## **Schedule – Further Information Request**

Temporary Access Ramp - Plan
Scale 1:250

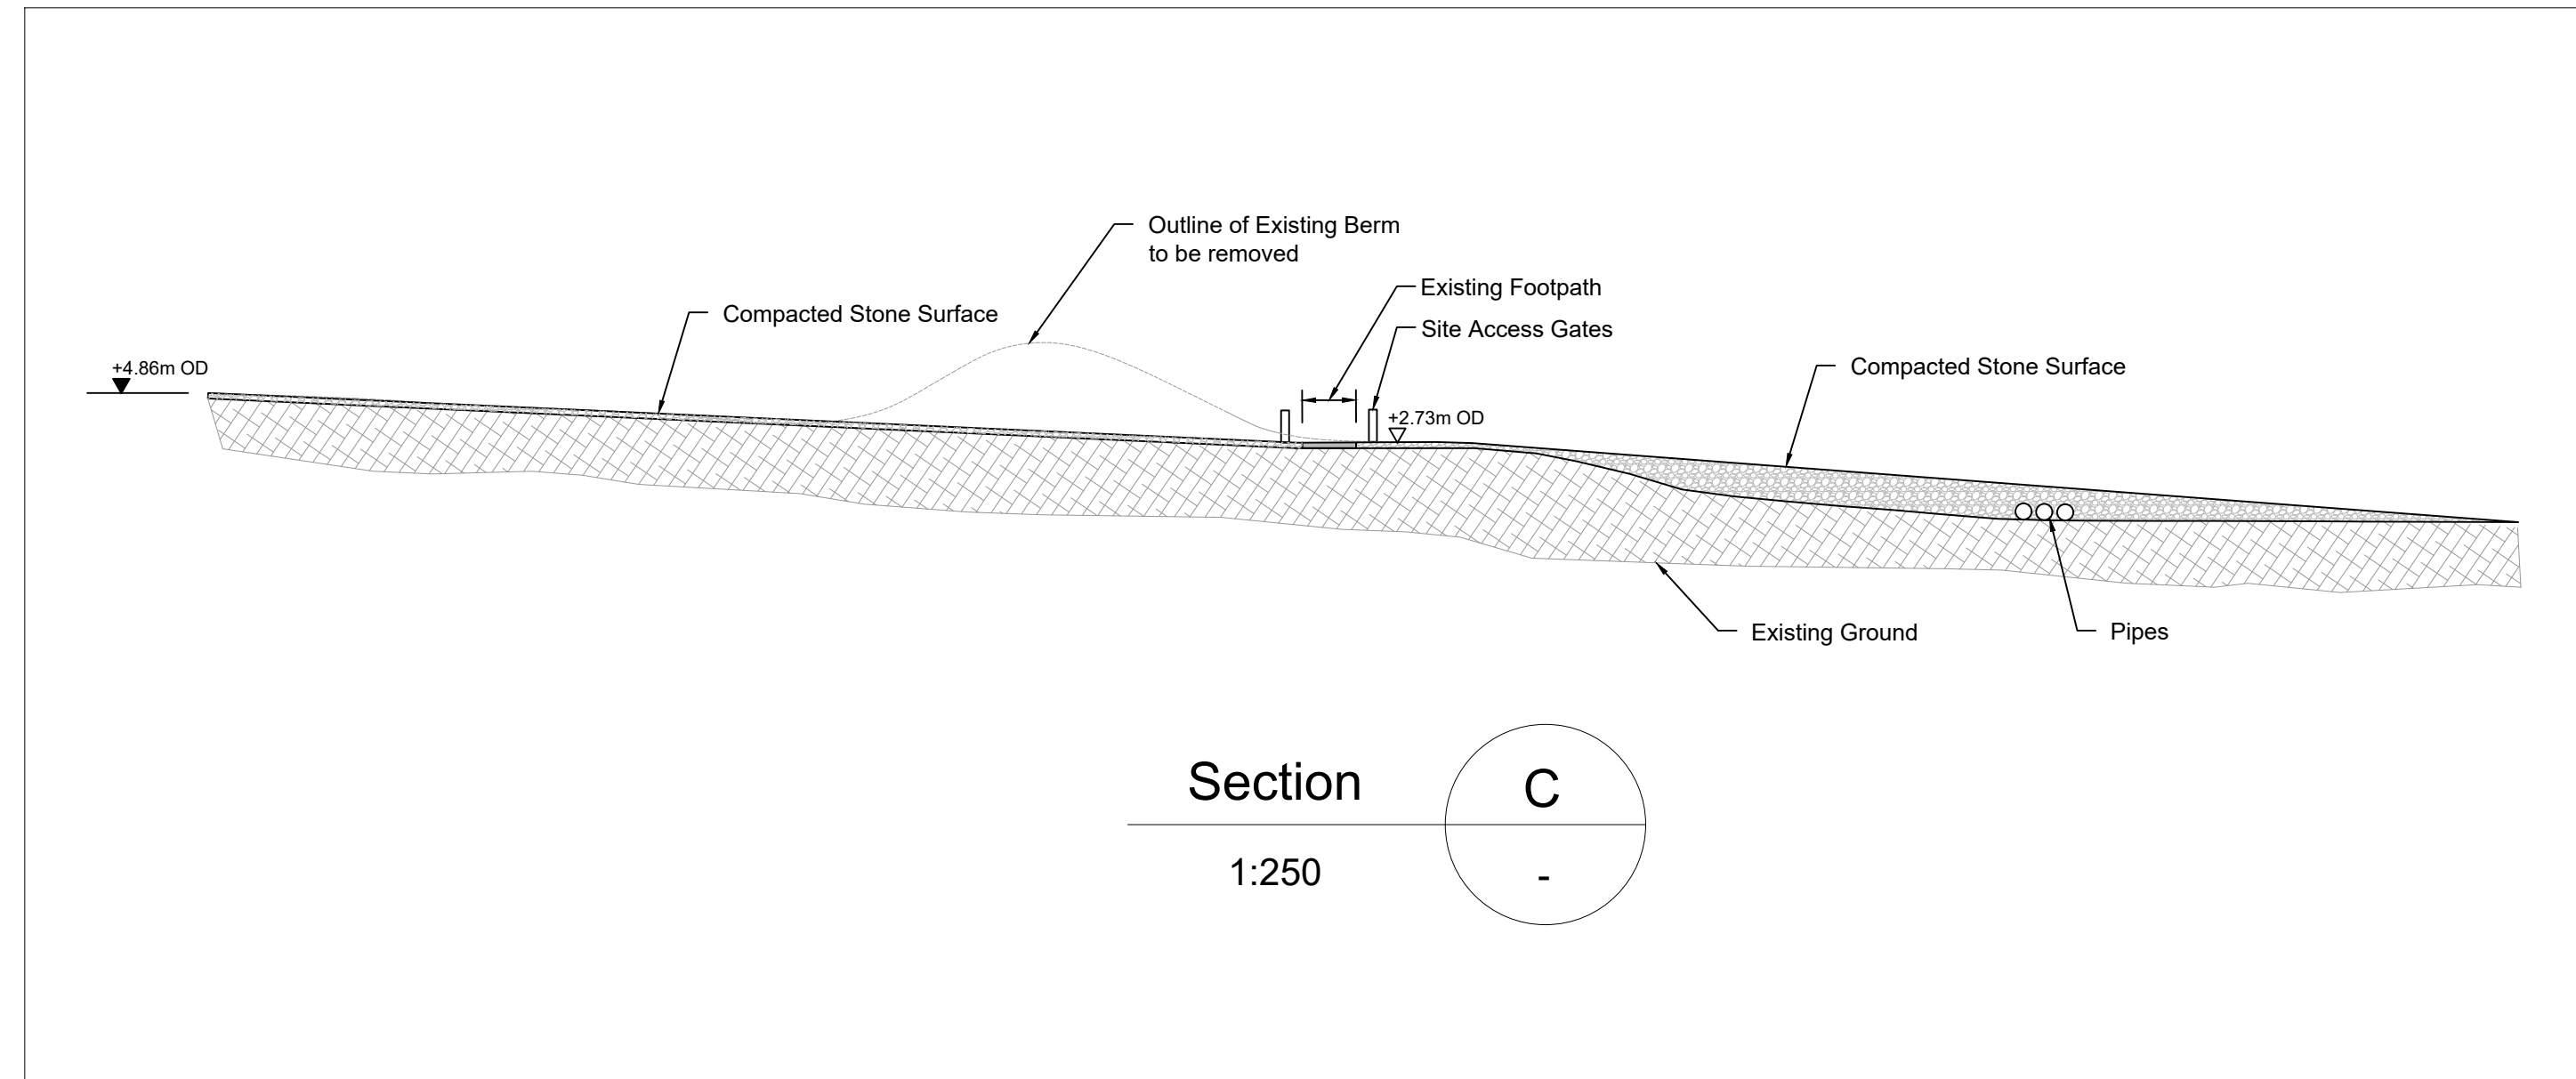
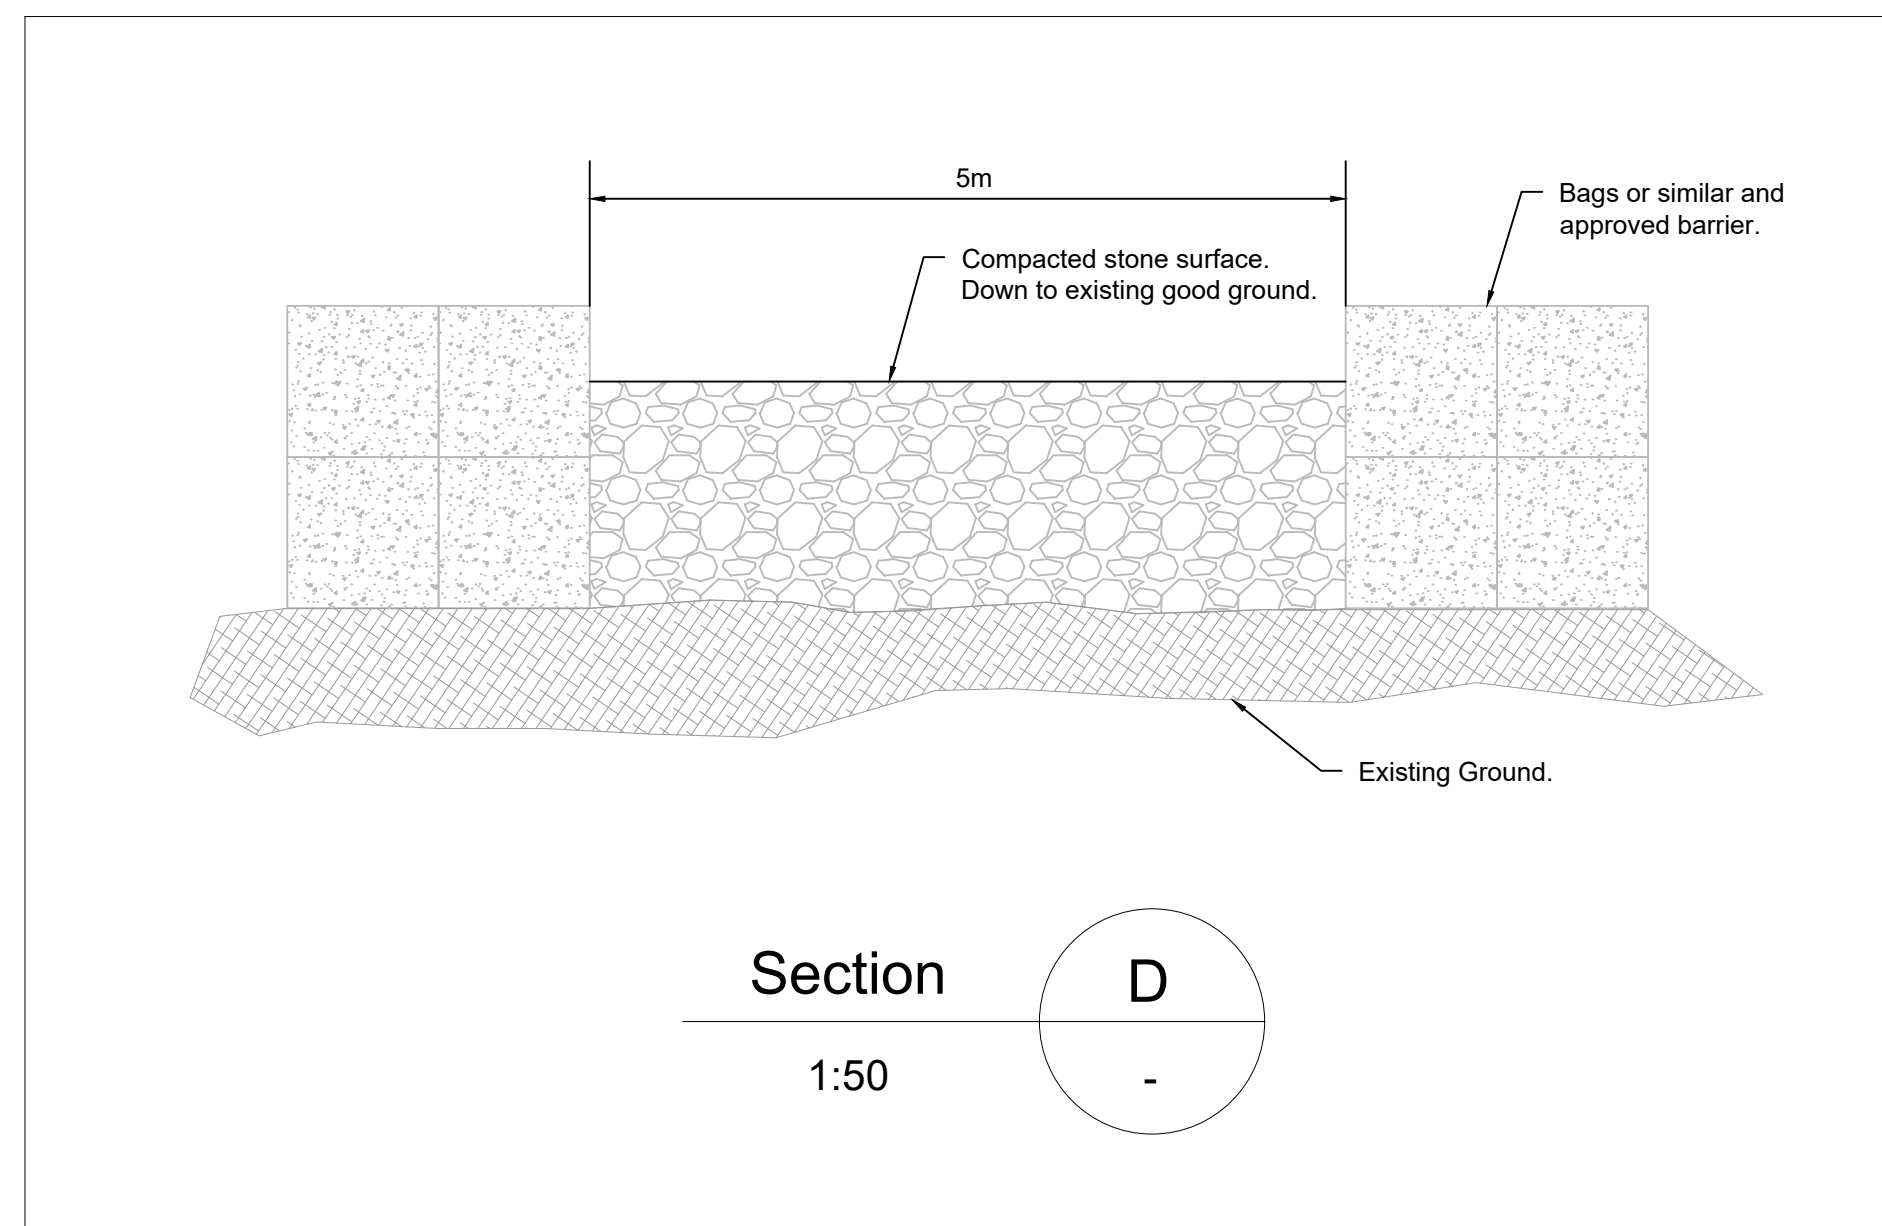
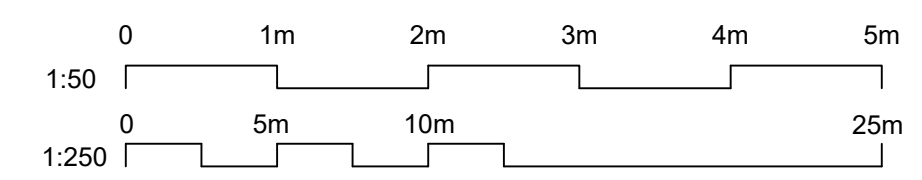
- g) (i) The Commission notes that a detailed assessment of the impact of the construction, operation and decommissioning phases arising from the provision of the offshore export cables through the intertidal zone has not been undertaken in terms of coastal processes. The applicant is therefore requested to provide a comprehensive assessment of the impact of these works on sediment transport, morphology, and intertidal sediment releases (including potential resuspension of contaminated sediment) as well as wave and currents across all phases of the proposed development within the intertidal area.

(iii) The Commission notes that the applicant is proposing the use of trench excavation (for a distance approximately 350m offshore from the HWM) throughout the intertidal zone. From the details submitted this construction methodology does not appear to be consistent with best practice (as noted in the DAU submission) in terms of on-shoring of export cabling through this sensitive intertidal area which is

designated as both an SAC and SPA. In this regard the Commission notes that the application documentation does not give sufficient (or any) consideration to the use of horizontal directional drilling (HDD) as a construction method through the intertidal area. The applicant is therefore requested to submit comprehensive environmental justification for the proposal to use trenching in this instance while also ensuring the protection of sensitive environmental features, species and habitats. Alternatively, in the absence of sufficient environmental justification for the use of intertidal trenching the applicant is requested to update all relevant application documentation to provide for comprehensive assessment of HDD through the intertidal area to facilitate the onshoring of the export cabling and amend any relevant responses to further information queries (such as at G(i) and G(ii) above) accordingly.
